Our Ref: 222/583 (1259150)

24 November 2016

**Re: SUBMISSION ON THE MARTINS CREEK QUARRY EXTENSION PROJECT (SSD 6612)**

Drawing Title
**MARTINS CREEK QUARRY
ROAD TRANSPORT ROUTES**

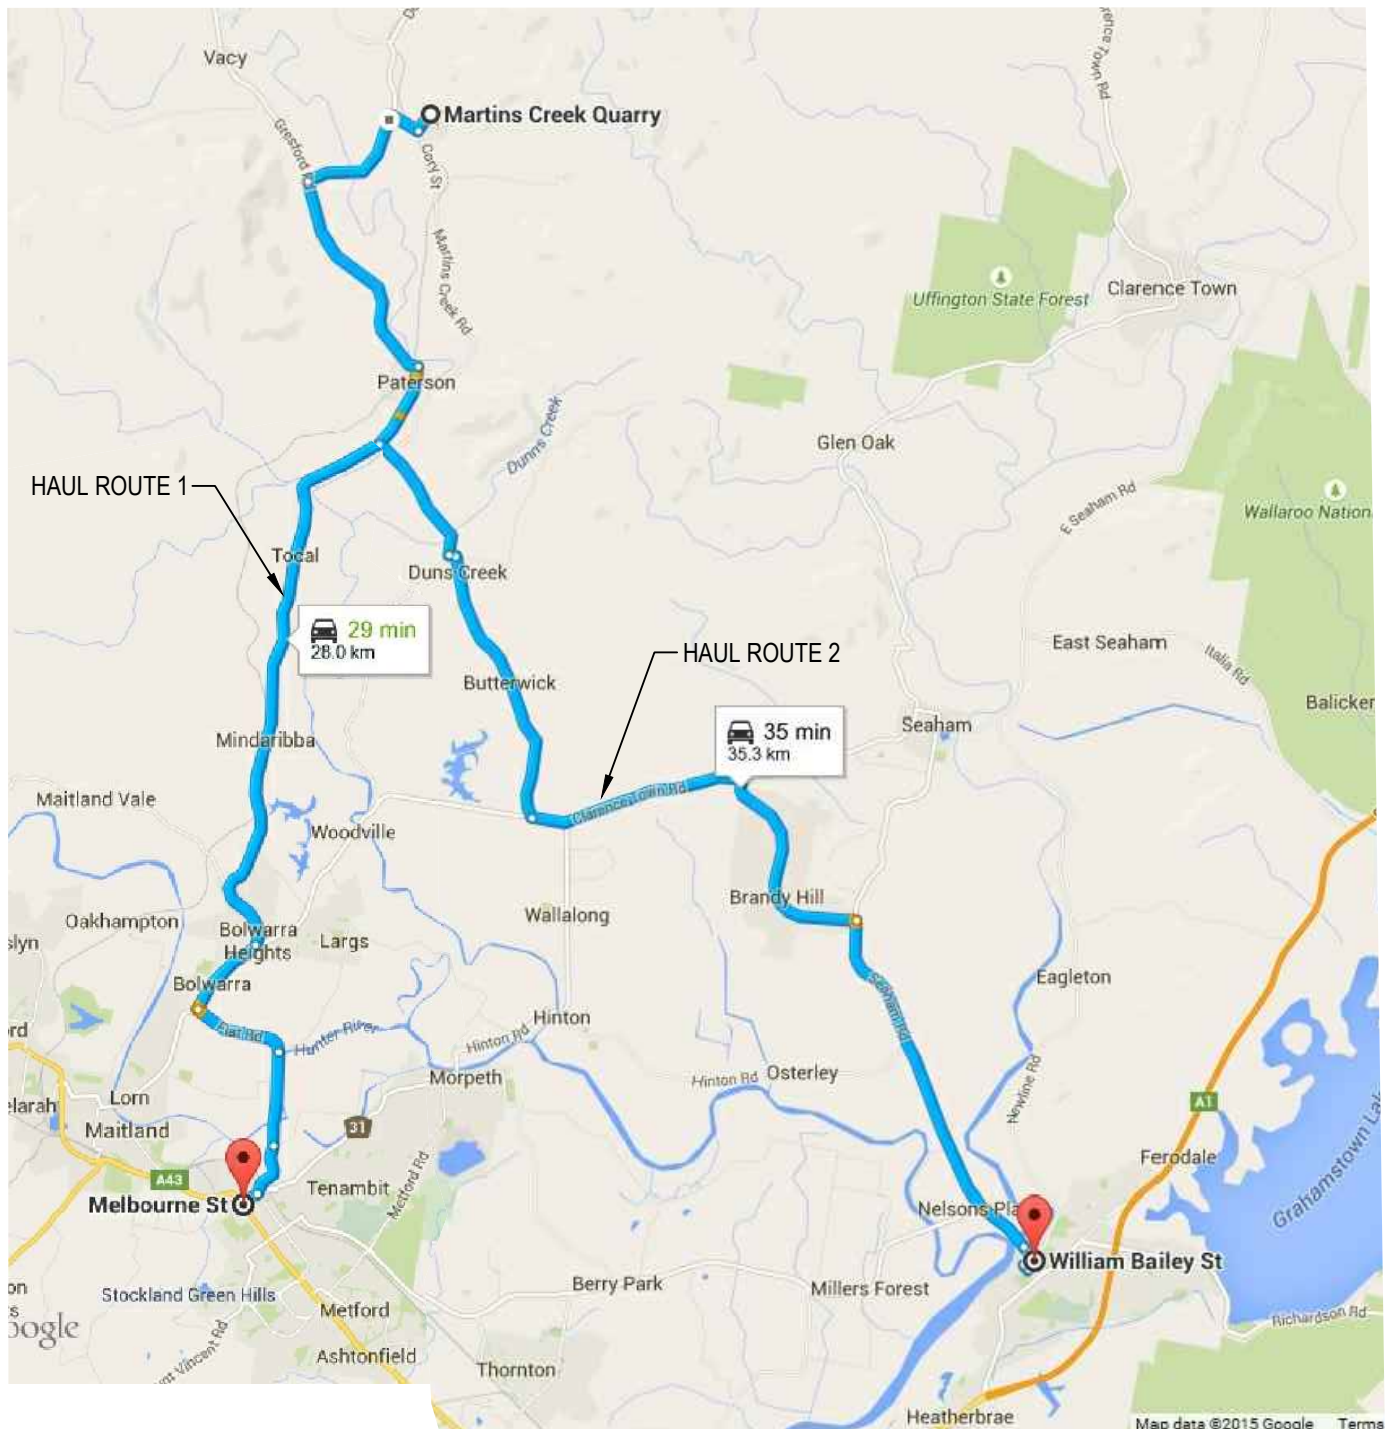
Council acknowledges the main access route through the Maitland LGA being Route 1 (EIS Vol. 2 Appendix H - SECA Solution Traffic Impact Assessment August 2016): Martins Creek Quarry – Grace Avenue – Dungog Road – Gresford Road – Tocal Road – Patterson Road – Flat Road which then connects to the state road network Melbourne Street – New England Highway.

Notwithstanding the suggested limitation of 215 one way truck movements per day, the proposed volumes of 430 truck movements per day (two-way) is still considered high. The proponent is justifying the movements from historical figures of truck movements in the Traffic Impact Assessment (TIA) (Table 2.7) based on a six day week over 50 weeks.

Using this reckoning to move 1.5 million tonnes would work out at an average of 308 (two-way) truck movements per day. The effect of 120 less truck movements a day would reduce complaints about the number of trucks travelling in built up areas. This would be closer to Council historical figures of heavy vehicle movements for this class of road in a rural environment.

Historically the Flat Road haulage route on an average takes only 61% of the product, the number of trucks to move this volume of material would be 188 two-way truck movements.

The issue is when the quarry has a contract to supply material to a project. The contract is driven by a timeline and the quarry under its own estimation can move 10,237 tonnes per day or 640 truck movements at peak capacity. It is at these volumes that the residents along the route are most affected by as nearly 3.5 times as many trucks could be on the Flat Road haulage route.

The operators have indicated that their normal truck movements will be restricted to 430 two-way movements a day with a morning peak of 40 laden trucks per hour. There is some concern over the resulting hourly volume and its implications on the queuing of commuter traffic at the intersection of Pitnacree Road and Melbourne Street, East Maitland.

The stacking of trucks at the intersection and their ability to move off within a reasonable time will have an impact on normal traffic flows. This needs to be investigated and assessed during normal truck movements, truck movements at maximum extraction and at peak hour haulage rate to determine the stacking of trucks and their impact on queuing at these traffic signals.

1. The quarry operator prepare a Transport Management Plan (TMP) in consultation with Maitland City Council to minimise the traffic impact on residents located along designated access routes to the quarry.

6. Limit heavy vehicle volumes to specific periods of the day to minimise impact on residents and road traffic service levels.
